RE: **Warehouse, 4455 Anaheim  
Grading and Drainage Plan  
Engineer's Stamp Date 6-11-2015 (File: C17-D123)**

RE: **Warehouse, 4455 Anaheim**  
**Grading and Drainage Plan**  
**Engineer's Stamp Date 5-13-2015 (File: C17-D123)**

**DRAINAGE REPORT**

ENGINEER'S SEAL	4455 ANAHEIM NE	DRAWN BY WCWJ
	GRADING AND DRAINAGE PLAN Rio Grande Engineering 1606 CENTRAL AVENUE SE SUITE 201 ALBUQUERQUE, NM 87106 (505) 872-0999	DATE 5-13-15
		SHEET # —
		JOB # 21515

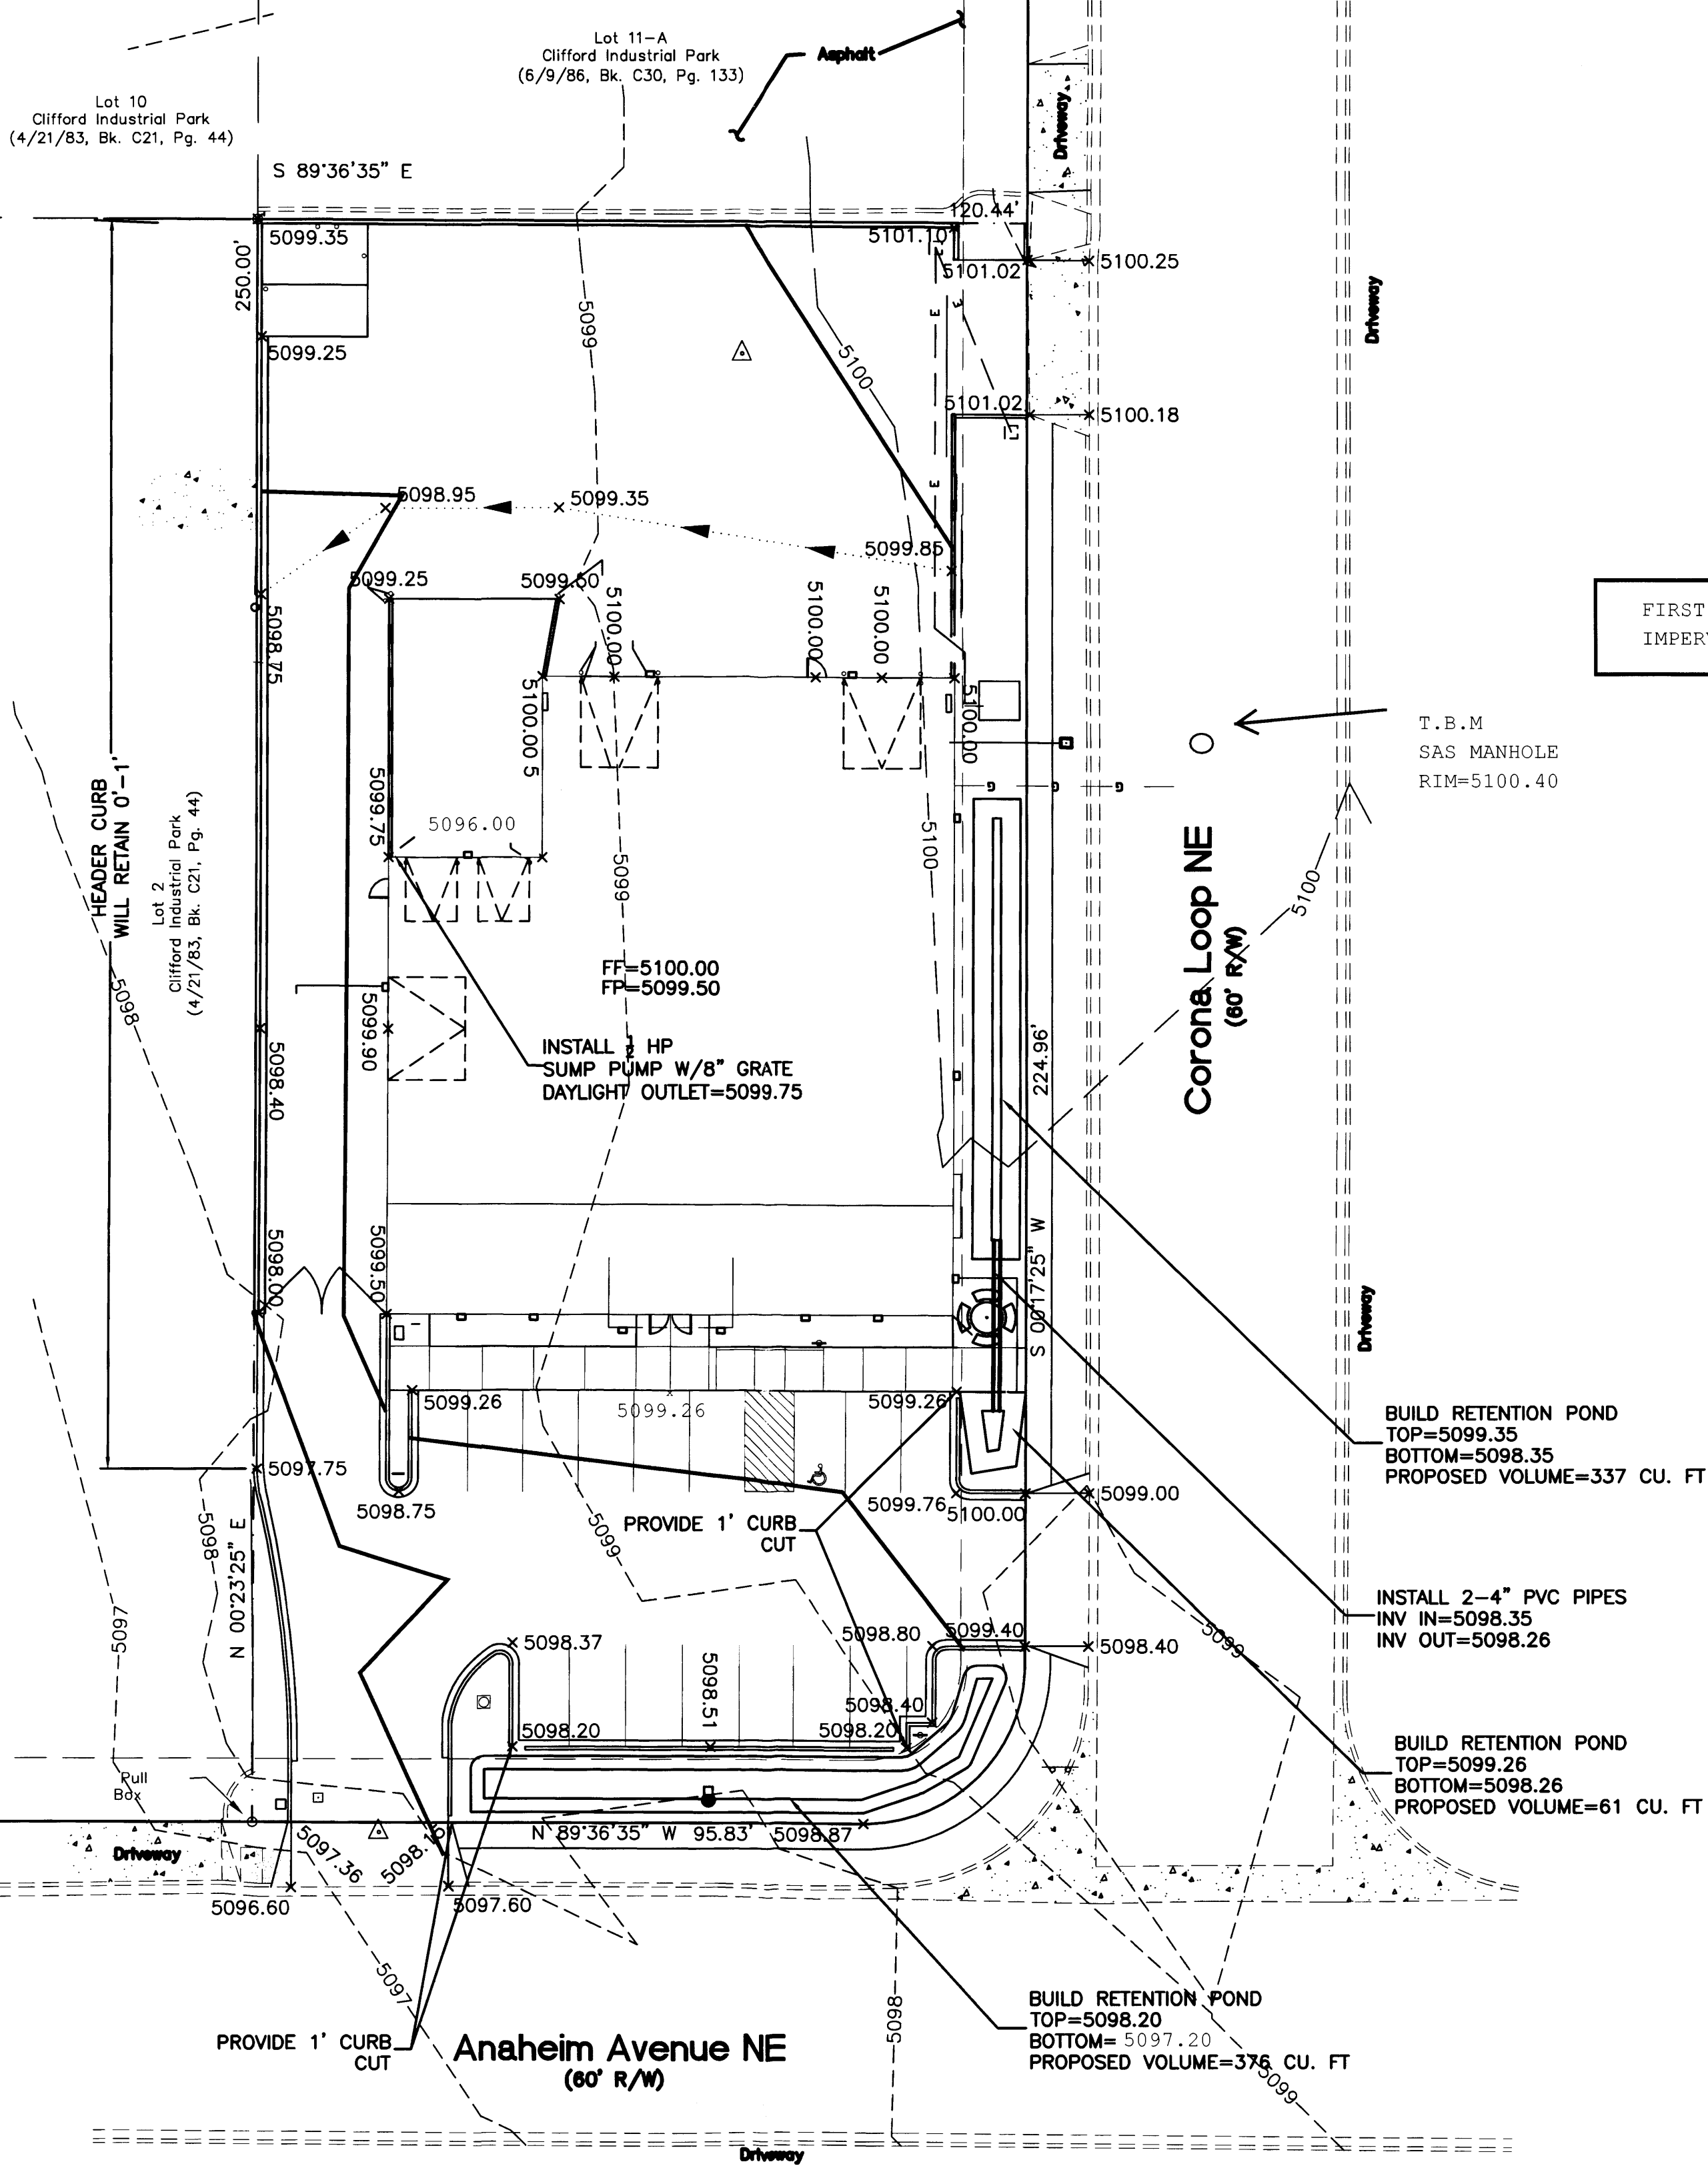
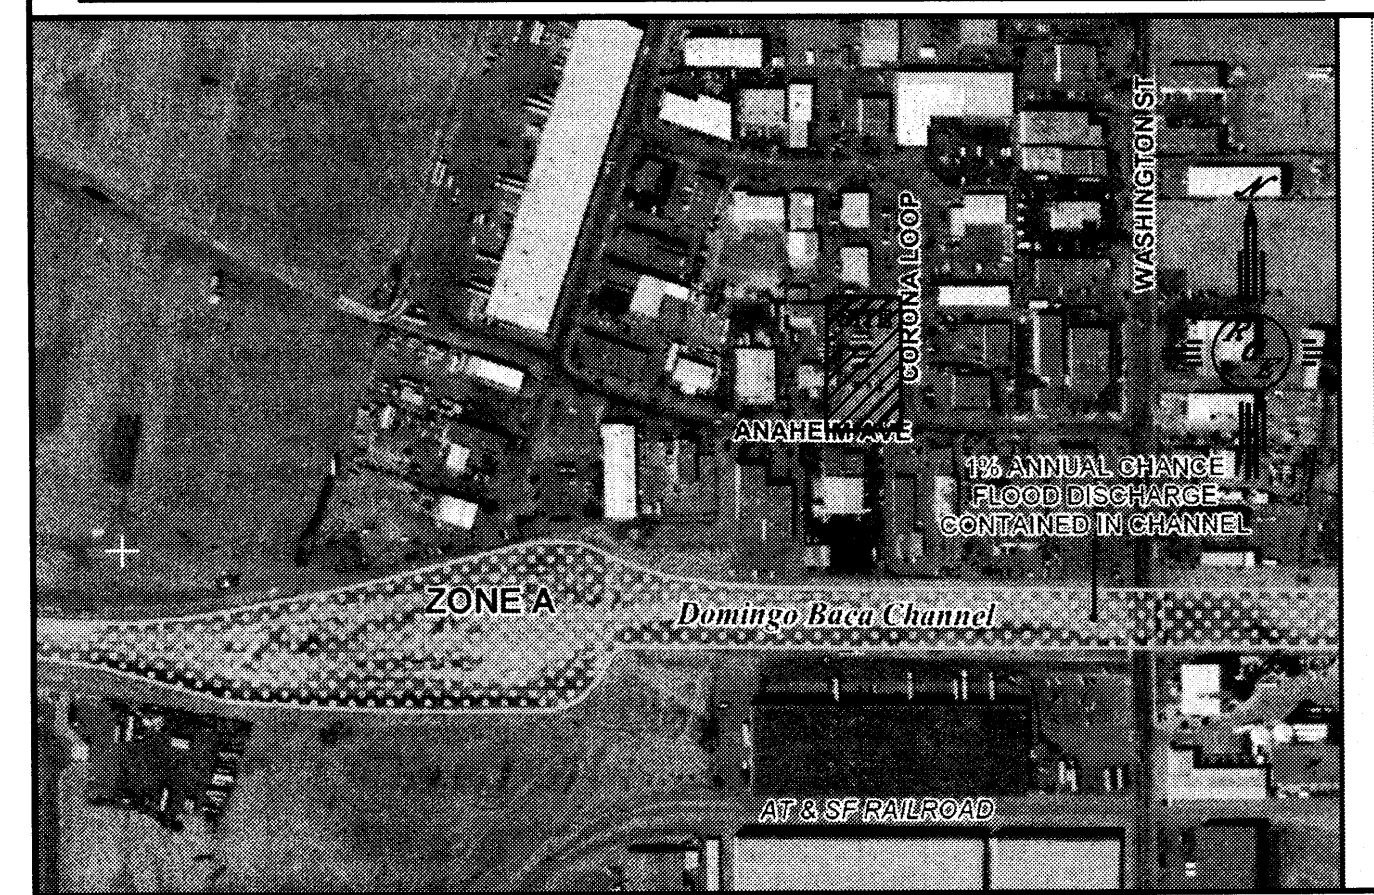
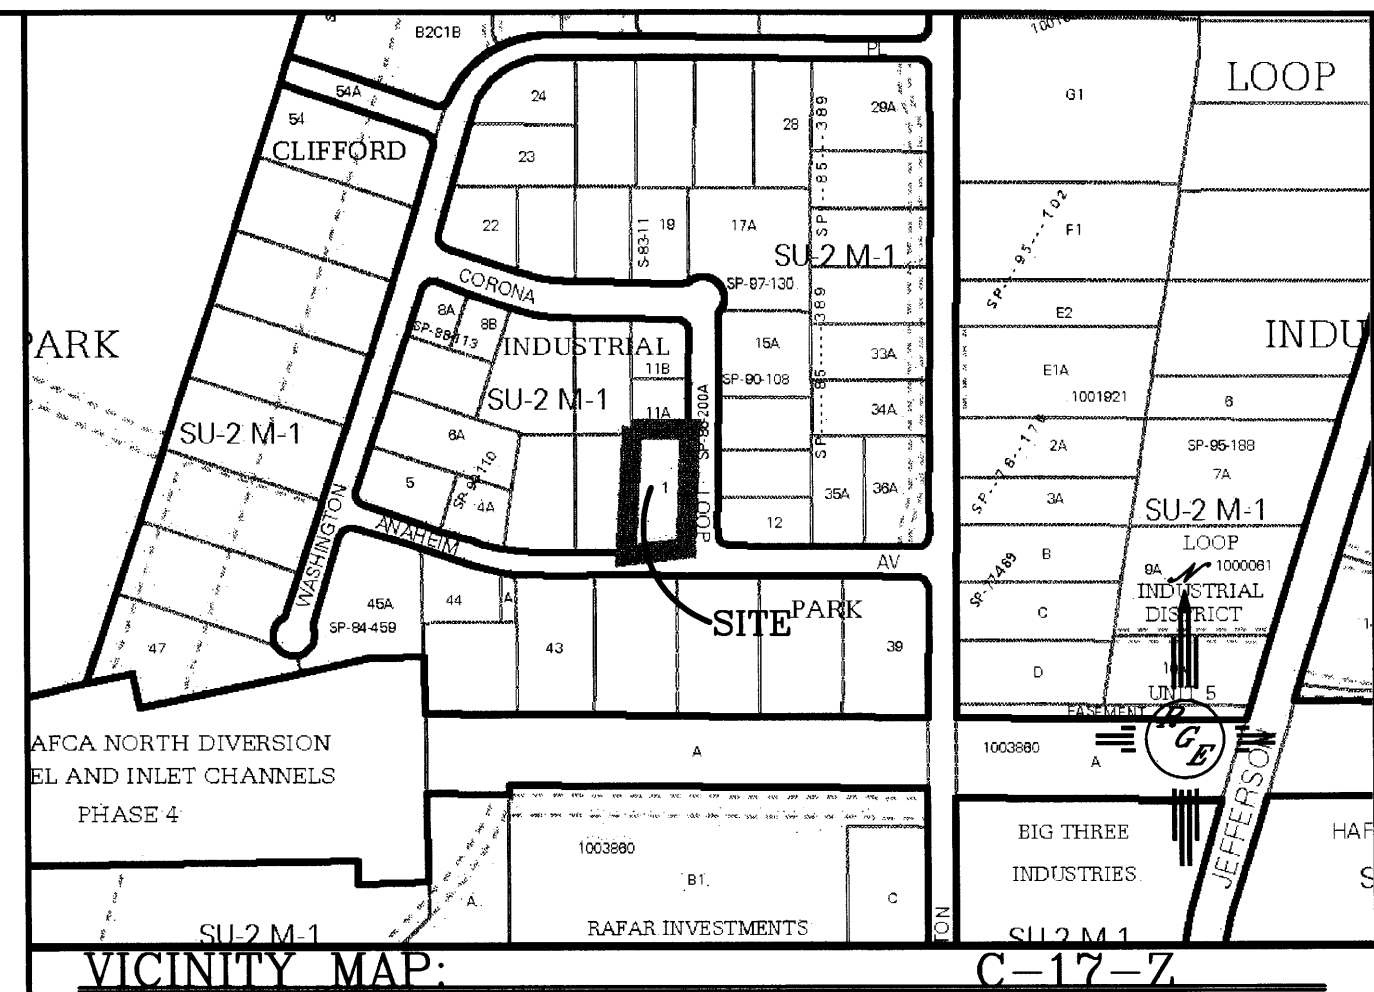
- 1) Provide new and existing curb linetypes and building boundary within legend. Label any gravel areas as "gravel" and paved areas as "paved", and count gravel lot areas as land treatment type "C". Label any new curb and curb height on the plan view as applicable. **We have label the apphalt and curbs**

- 2) Show roof drain locations. **We have added direction and downspouts**
- 3) Show existing spot elevations for curb on Corona Loop and on Anaheim Avenue. Label proposed contours, and additionally provide boundary lines around each of the pond areas that define the top and bottom elevations of the pond. For the three retention ponds, indicate that they are for the "first flush" if this is the case. If new spot elevations provided are at flowline of curb, provide general note stating this. **added spots. line tyoes. labeled ponds. note #1 states spots flowline**
